ExQ1: Tuesday 19 November 2019
Broadland District Council Responses
ID Ref. 20022881

ExQ1	Question	Response
Q1.2.2	<p>Listed buildings in Cawston Further to RRs [RR-018], [RR-019], [RR-105], Additional Submission [AS-038] and the Applicant's response to RRs [AS-024, Table 19, No.3] are you:</p> <ol style="list-style-type: none"> 1. satisfied that construction stage effects on listed buildings in Cawston have been adequately assessed; 2. content with the findings in terms of the significance of any identified impacts upon those assets and their settings and the level of any harm and loss of heritage significance? 	<ol style="list-style-type: none"> 1. No, the details of the proposed highway mitigation scheme through the village of Cawston remain to be finalised and have not been agreed with Norfolk County Council's highways department, Cawston Parish Council or Broadland District Council. Therefore the construction stage effects on listed buildings in Cawston have not been assessed. 2. As above, this matter remains to be resolved.

Title:
Noise receptor locations
(Map 2 of 9)

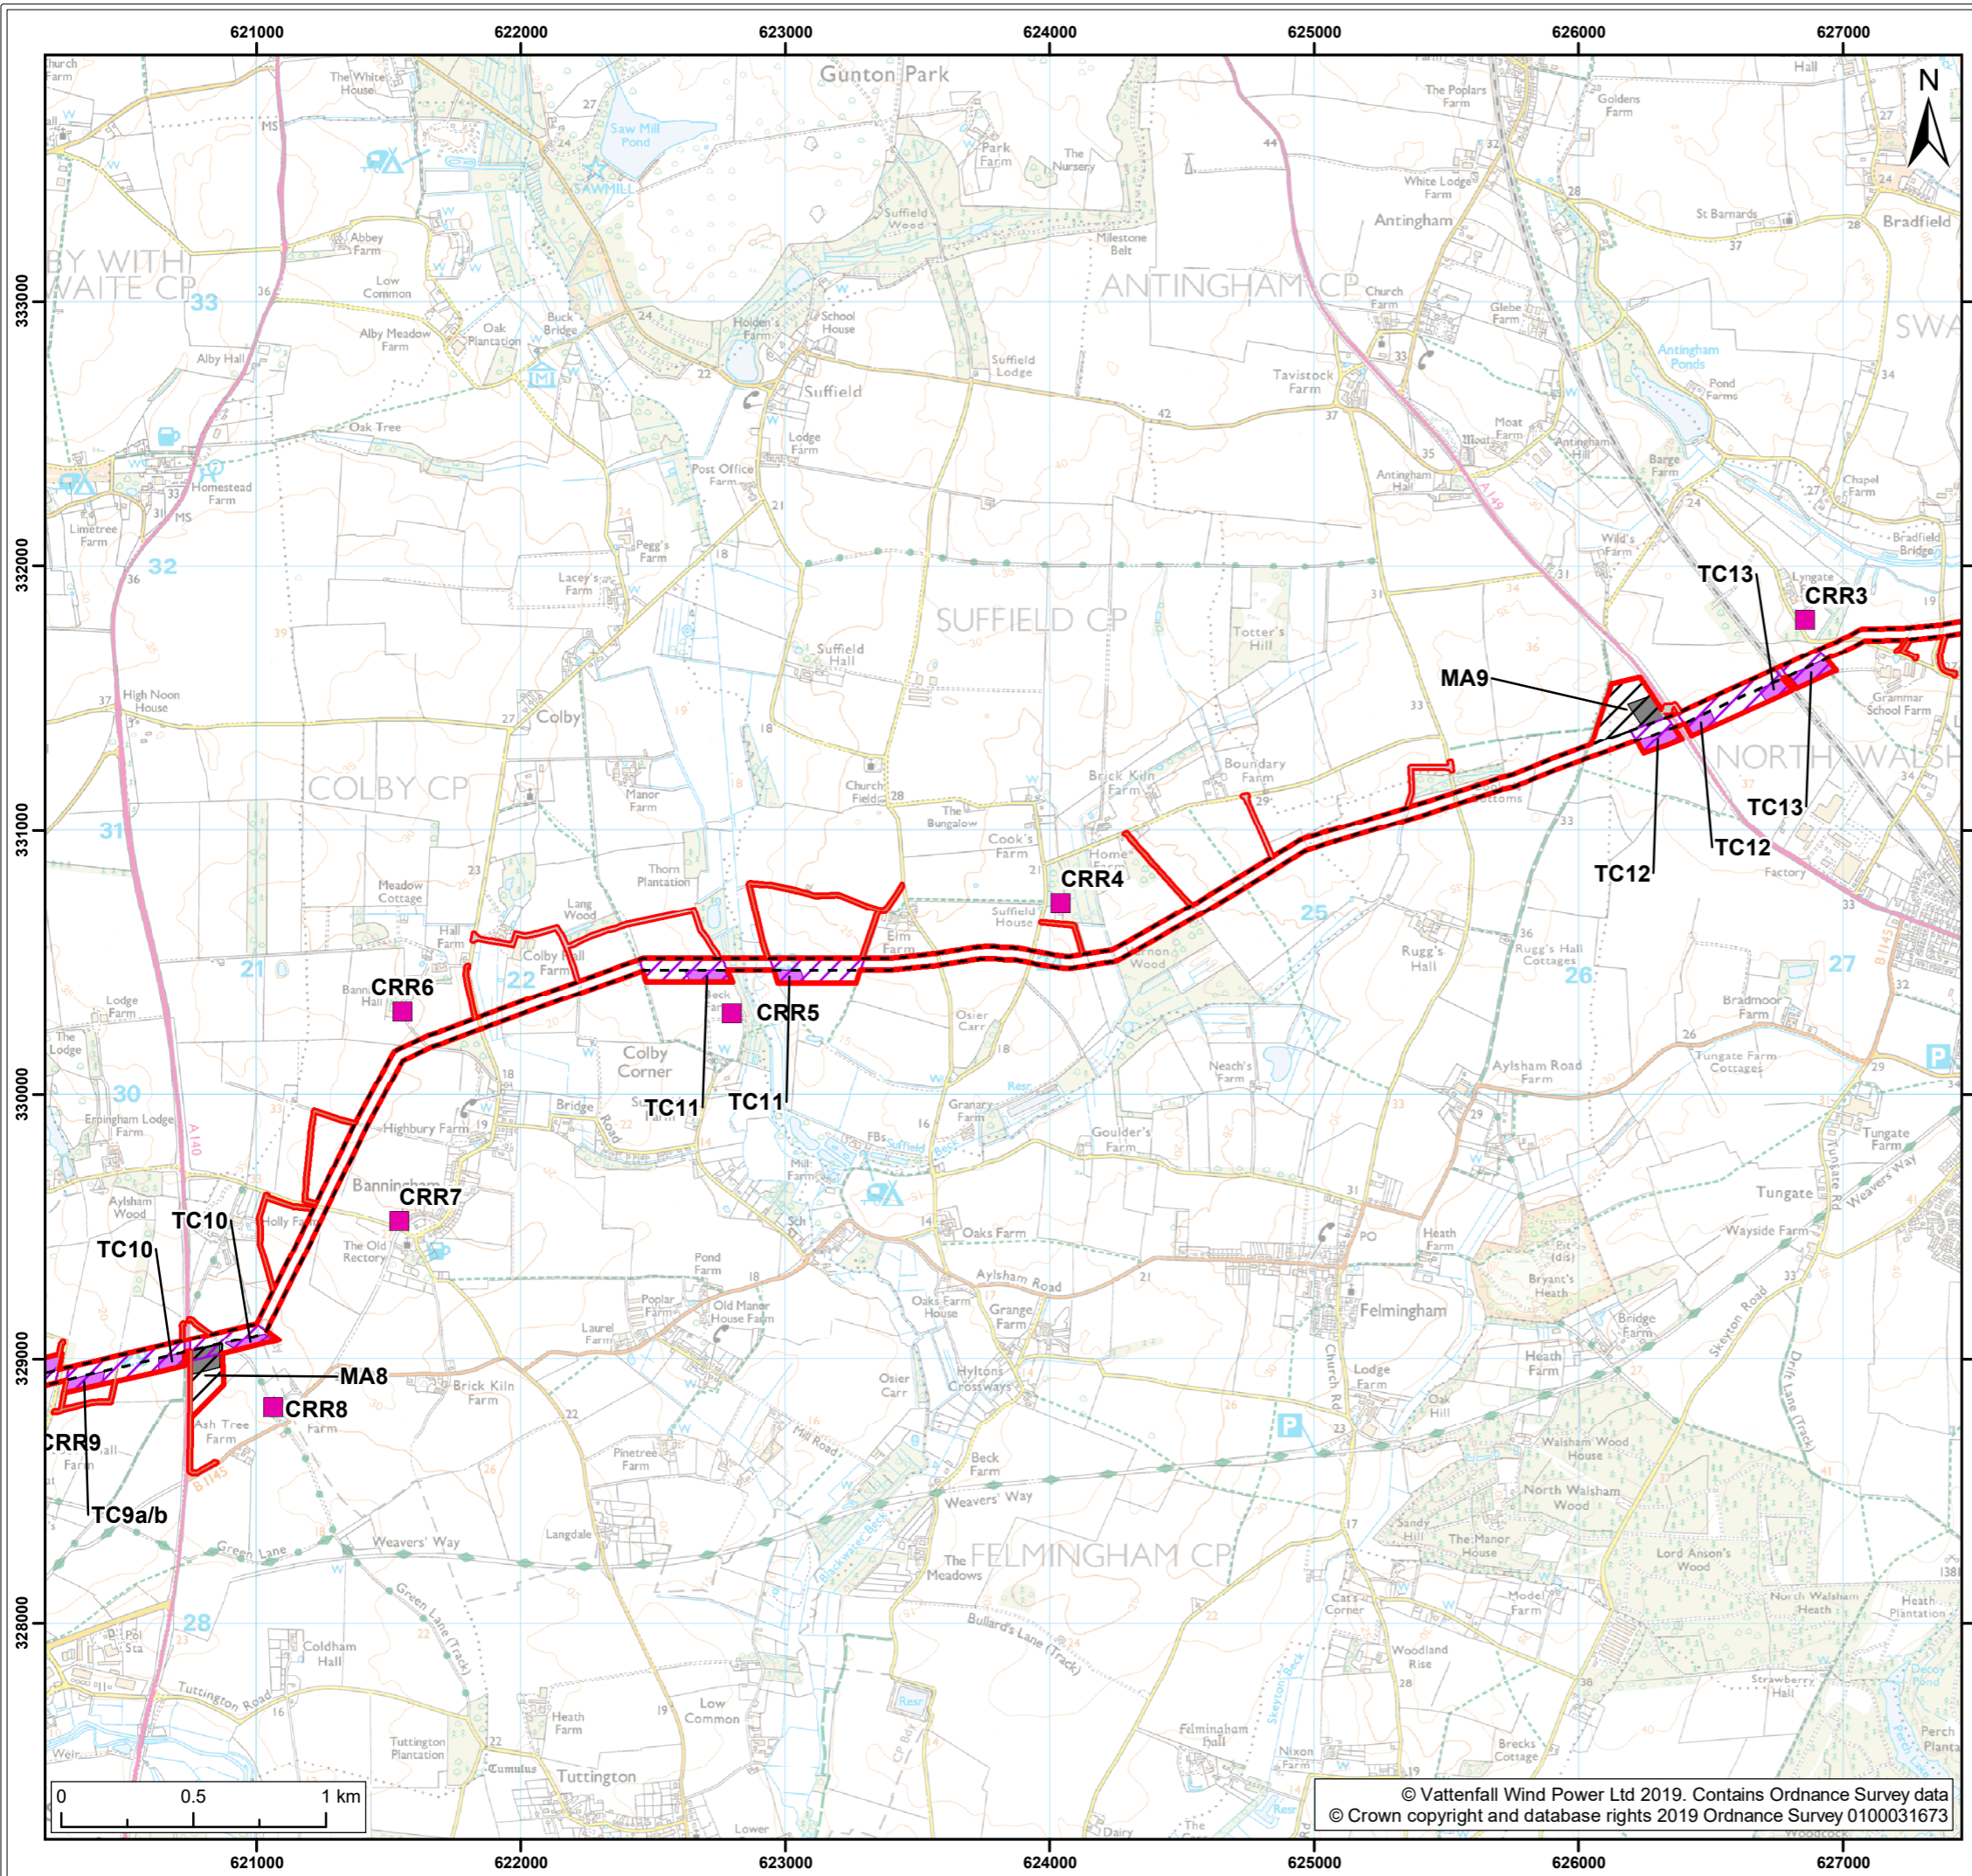
ExQ1	Question	Response
	<p>properties in proximity of this area (see map 2 of 9);</p> <p>4. there are no NSRs in proximity of TC6, although there are a number of farms in proximity of this area (see Map 6 of 9)?</p> <p>5. IPs may wish to comment.</p>	
Q14.0.6	<p>Traffic effects in Cawston and Oulton</p> <p>The RRs from Broadland District Council [RR-028], Cawston Parish Council [RR-016] and Oulton Parish Council [RR-017] raise concerns about the traffic assessment surrounding the villages of Cawston and Oulton. This includes concerns regarding the same access routes to Norfolk Vanguard, the Proposed Development and Hornsea Project Three during potentially the same time frame, and traffic impacts on the B1145 through Cawston.</p> <p>The Applicant's response to the RRs [AS-025, Table 19, row 3] refers to a 'highway intervention scheme' developed by Orsted for the objective of mitigating the construction traffic impacts of Hornsea Three and cumulative impacts with Norfolk Vanguard and Norfolk Boreas through Cawston.</p> <p>1. The Applicant to confirm if it would adopt the same 'highway intervention scheme' to mitigate the construction traffic impacts through Cawston. If yes, the Applicant to provide details of the 'highway intervention scheme'.</p> <p>2. How has the impact of the proposed 'highway intervention scheme' been assessed in the ES Chapter 24 [APP-237]?</p> <p>3. In the response to the RRs [AS-025, Table 19, row 3], you refer to 'the final SoCG (REP9-047) with Norfolk County Council at the close of the</p>	<p>1. Applicant to advise</p> <p>2. Applicant to advise</p> <p>3. Applicant to submit</p> <p>4. NCC highways department to advise</p> <p>5. Yes, under Part 3 of the DCO as drafted, if a highway intervention scheme can be agreed.</p> <p><u>Cawston</u></p> <p>The details of the proposed highway mitigation scheme through the village of Cawston remain to be finalised and have not been agreed with Norfolk County Council's highways department, Cawston Parish Council or Broadland District Council. Therefore the traffic effects in Cawston have not been fully assessed and we reserve the right to comment further.</p> <p><u>Oulton</u></p> <p>In respect of the proposed cable logistics area (cla) on Heydon Road to the south of the village of Oulton, the District Council is concerned about the cumulative impacts arising from the construction traffic associated with three nationally strategic infrastructure projects in close proximity to one another and the following details are required:</p> <ul style="list-style-type: none"> the number of each type of vehicle that will require access to the cla each day (in and out),
